**A63 (Castle Street Improvement, Hull) – TR010016**  
**Deadline 7: Response by EPIC (No.2) Limited ("EPIC")**  
**IP URN: 20018241**

#### DRAFT ALTERATIONS TO THE DCO PROPOSED BY EPIC (NO.2) LIMITED (URN: 20018241)

Drawing Title: **WORKS PLANS REGULATION 5(2)(j) OPTION A SHEET 3 OF 6**

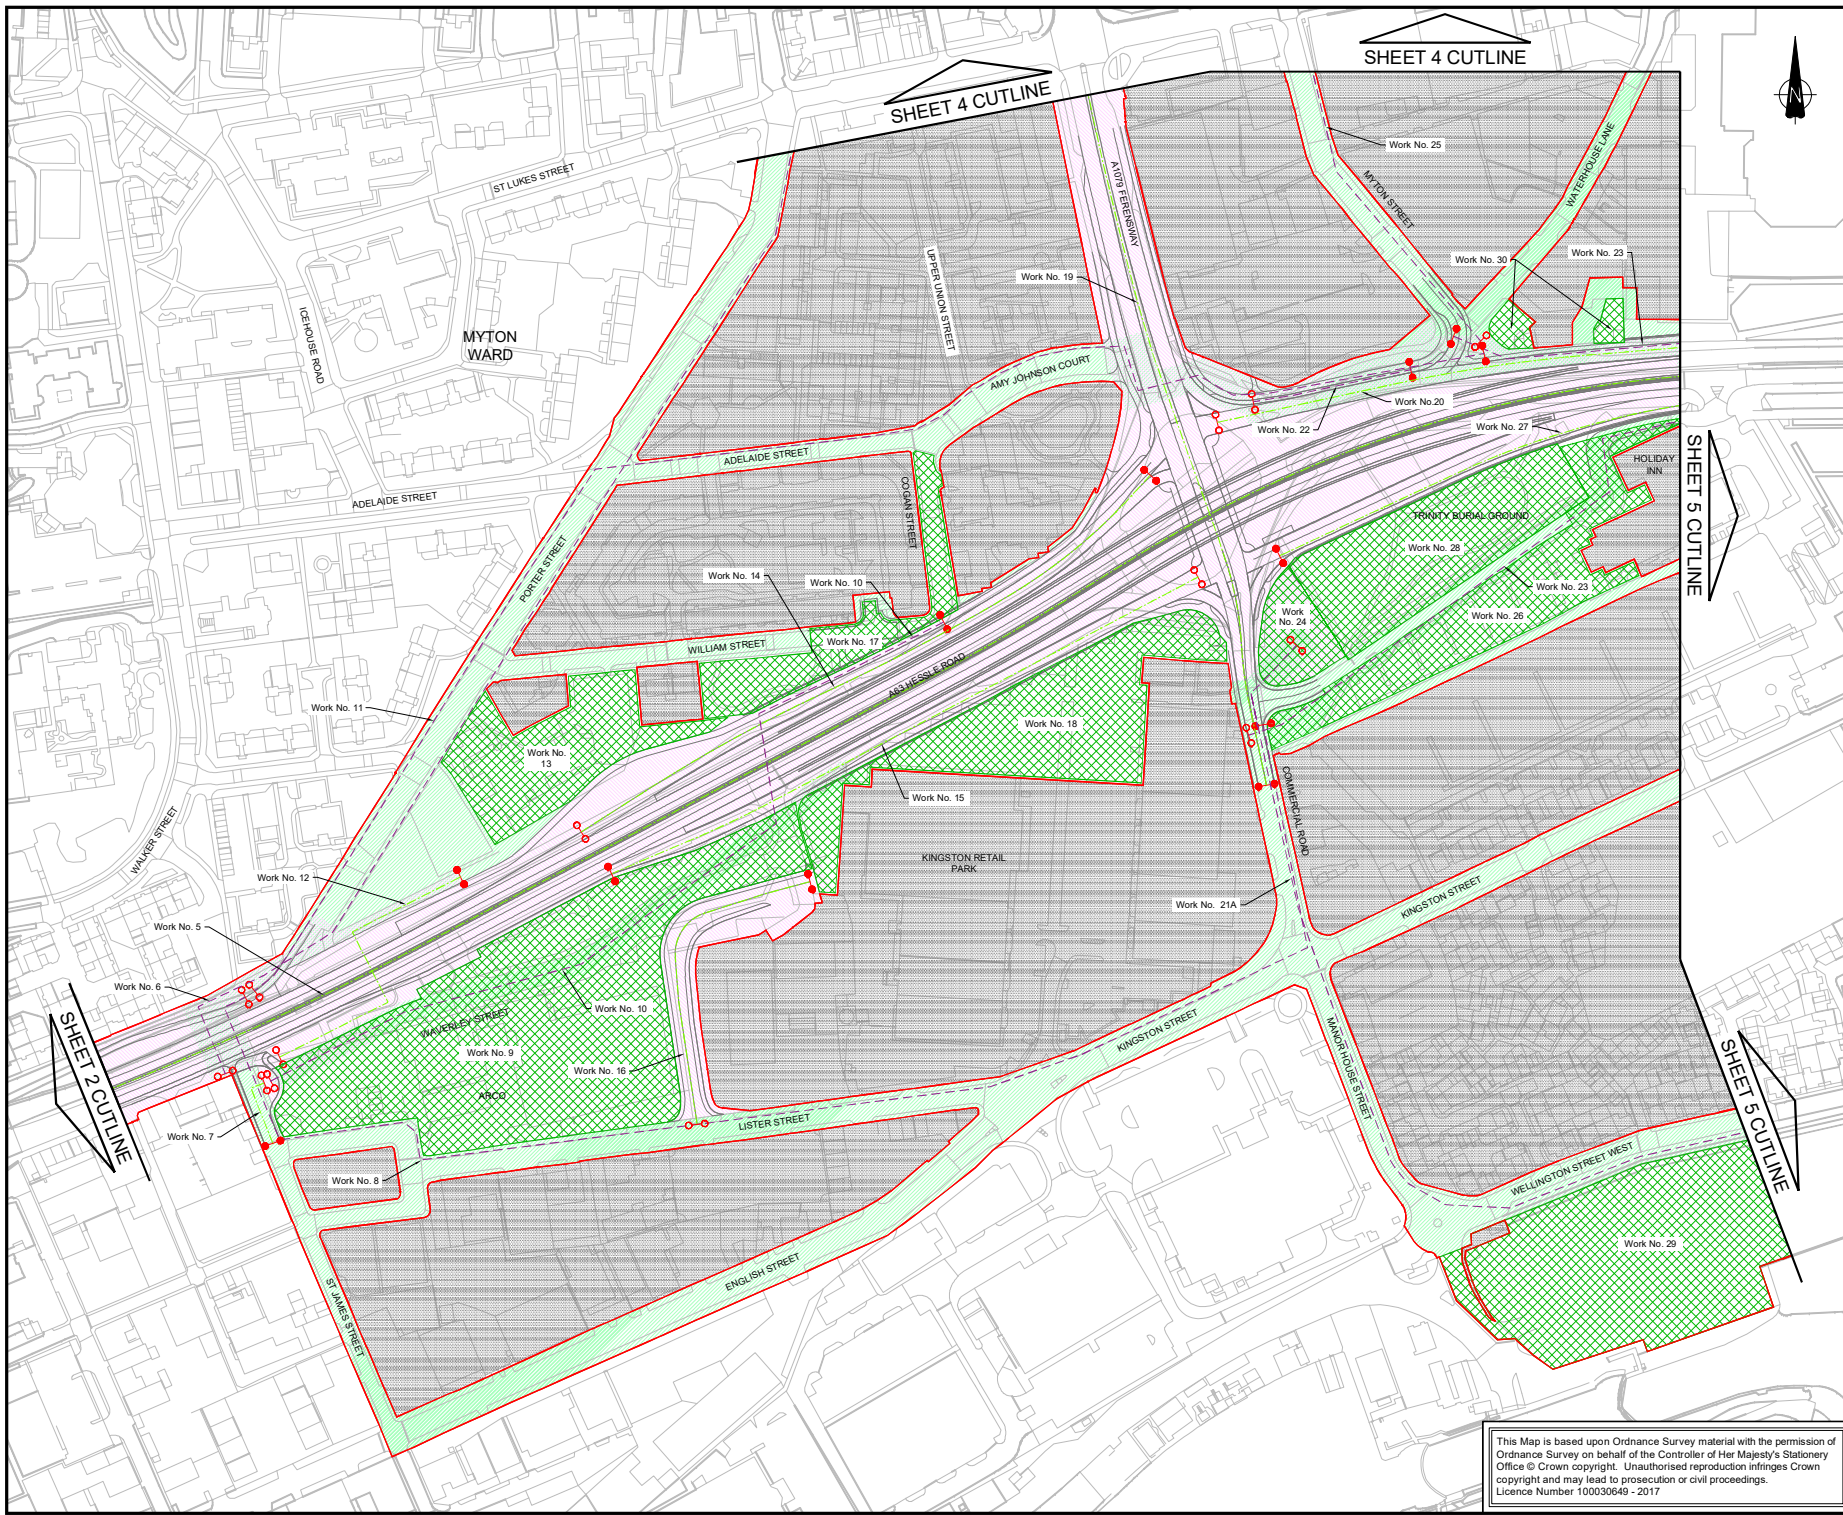
Schedule 1: the description for Work No 18B should be changed from: "Working room for statutory undertaker works" to "Alterations to Kingston Retail Park car park"

Drawing Title: **STREETS, RIGHTS OF WAY AND ACCESS PLANS REGULATIONS 5(2)(k) & 5(2)(o) OPTION A - SHEET 3 OF 6**

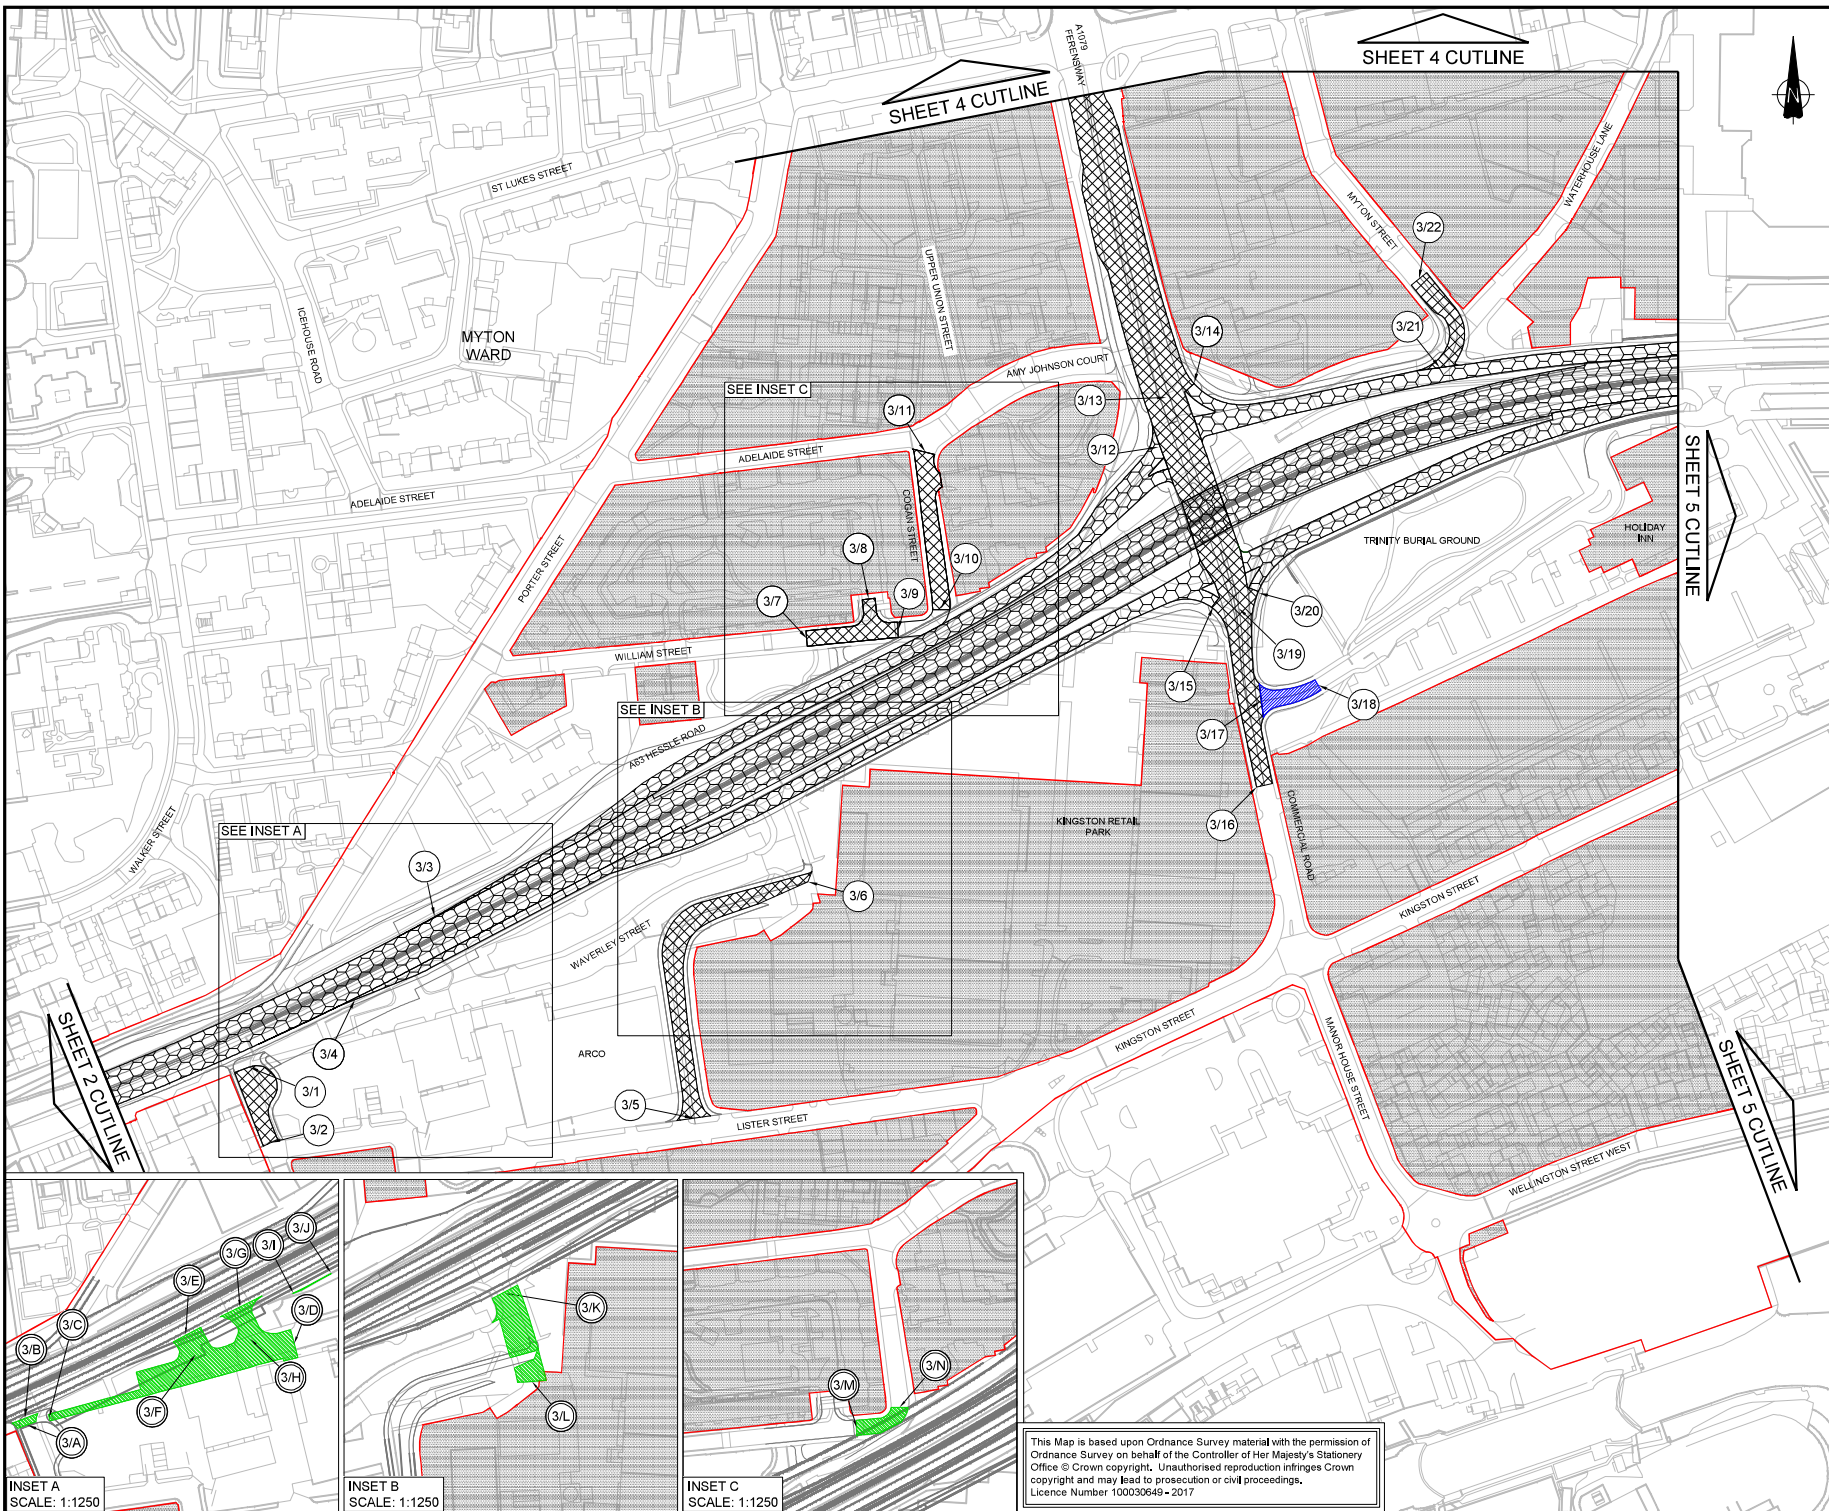
4.1.2 The Streets, Rights of Way and Access Plan Sheet 3 to be amended to show a highway being provided for the full width of the access to the western service yard of Kingston Retail Park.
